PREL/FINAL

DRB Application No.: 10DRB-70167 Project # 1008321
 Project Name: TRIANGLE REALTY
 Agent: ROXANNA HUSTON Phone No.:

Re: Minor Preliminary/Final Subdivision Request: Triangle Realty Tract A-1-A-2

PLAT OF  
**TRACTS A-1-A-2-A & A-1-A-2-B**  
**TRIANGLE REALTY, INC.**  
 (A REPLAT OF TRACT A-1-A-2, TRIANGLE REALTY, INC.)  
 ALBUQUERQUE, BERNALILLO COUNTY, NEW MEXICO  
 JUNE, 2010

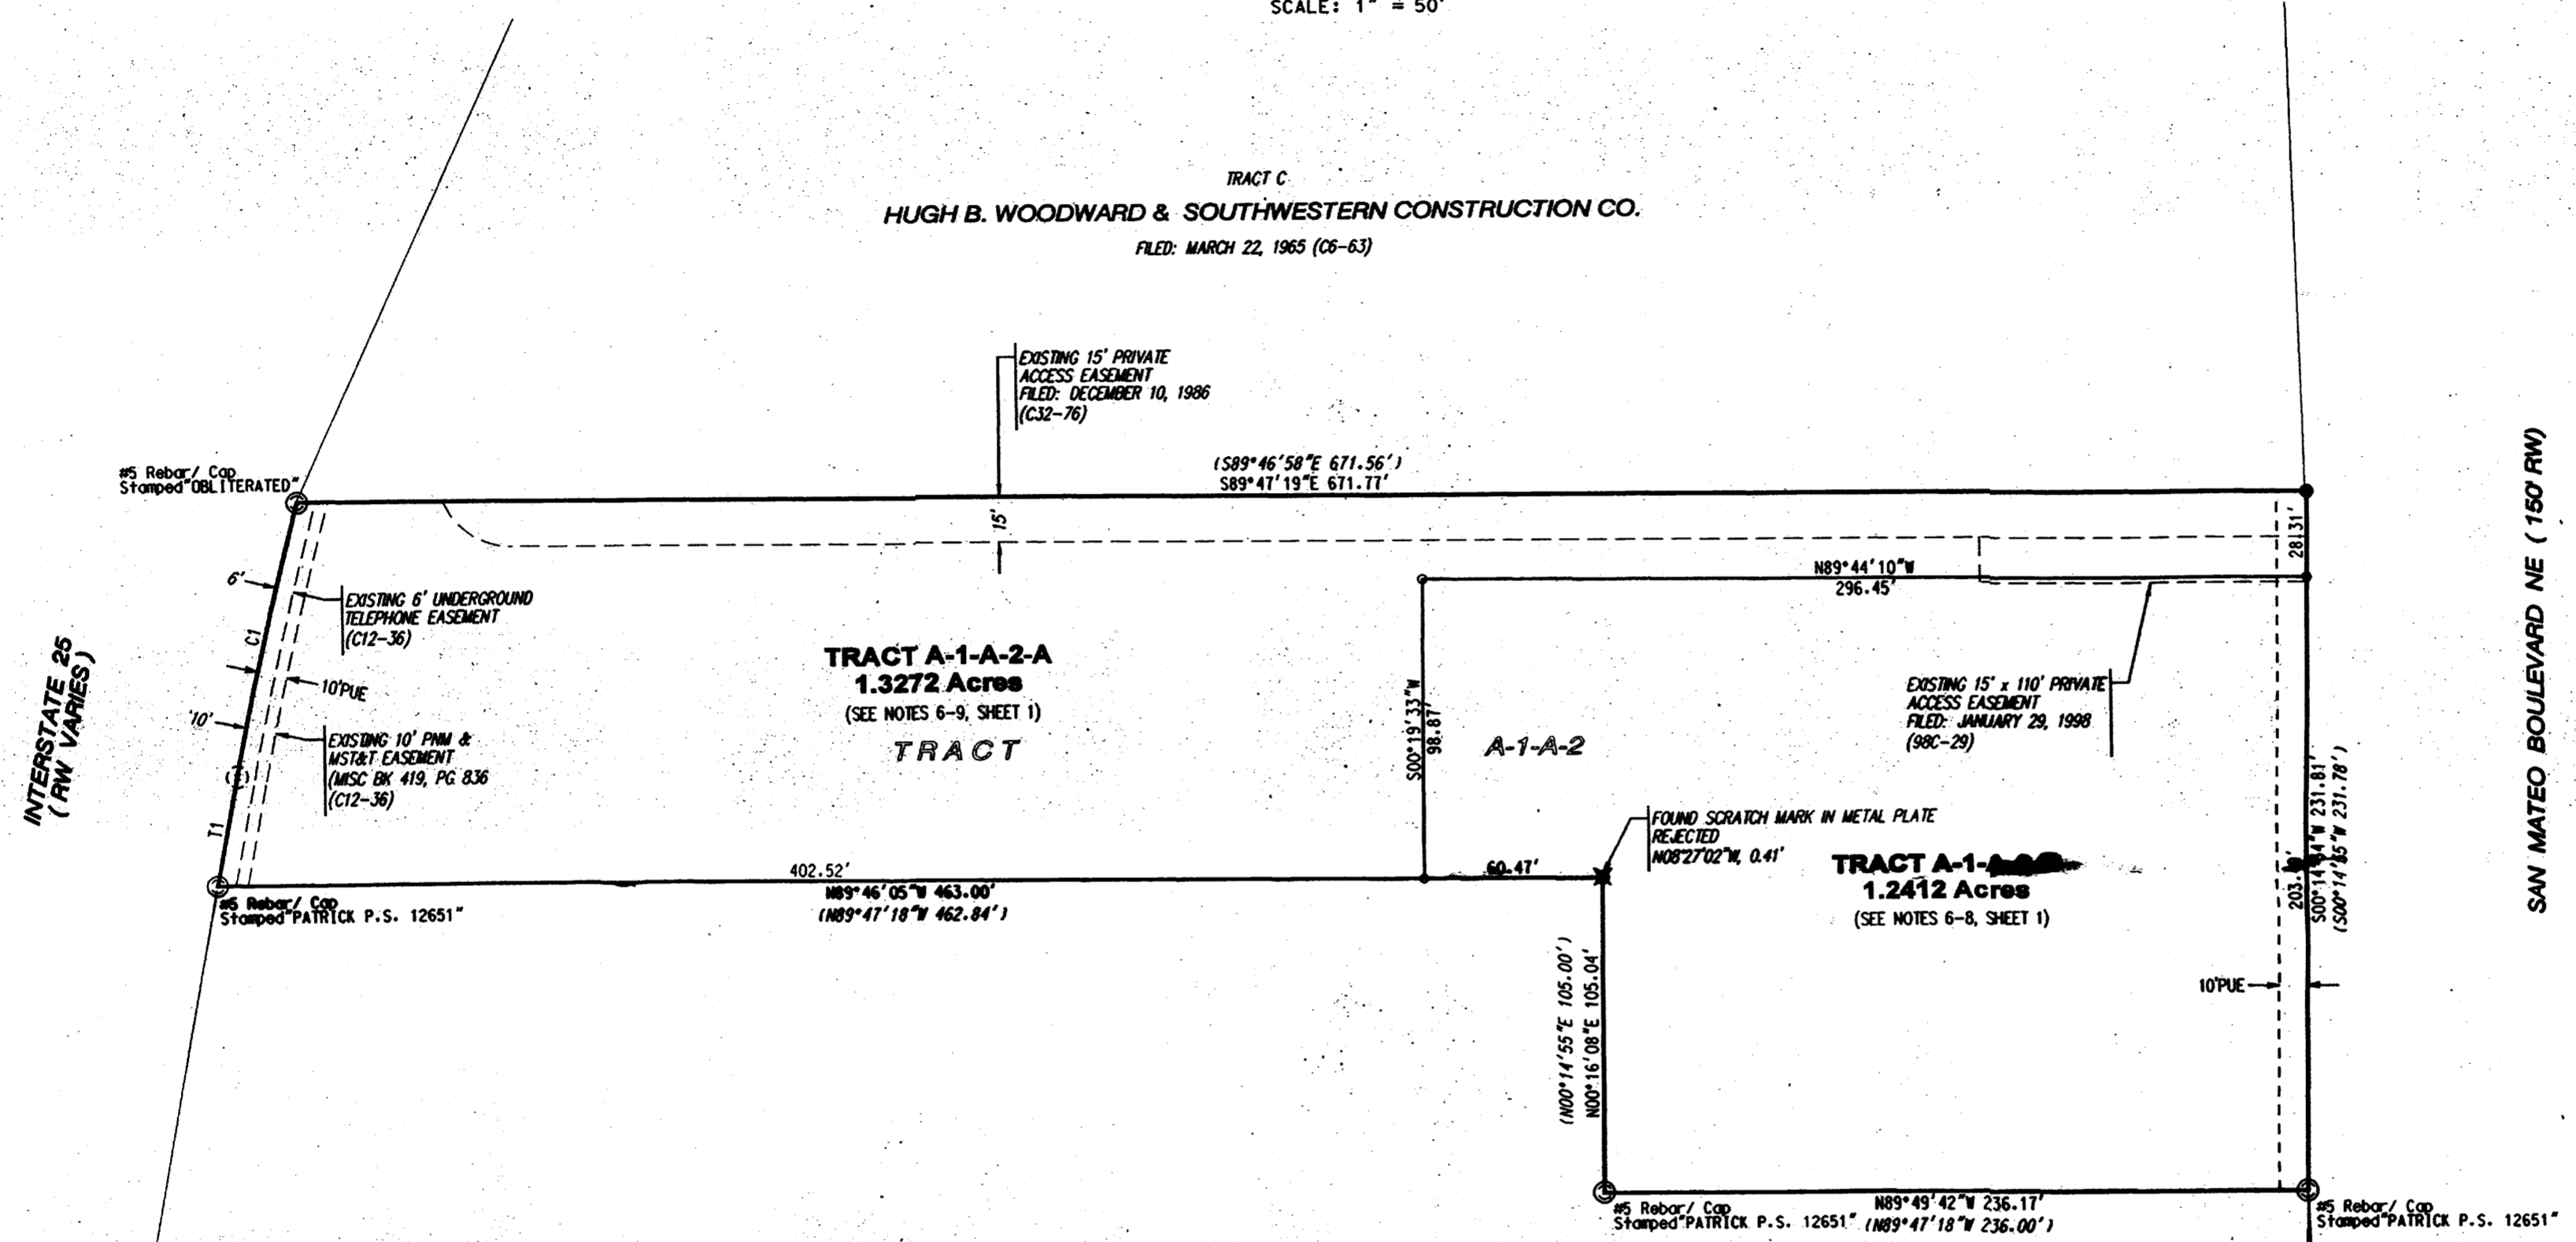
TRANSPORTATION: - clarify easements

PLANNING (Last to sign): - Utility & AMAFCA signatures
- clarify easements
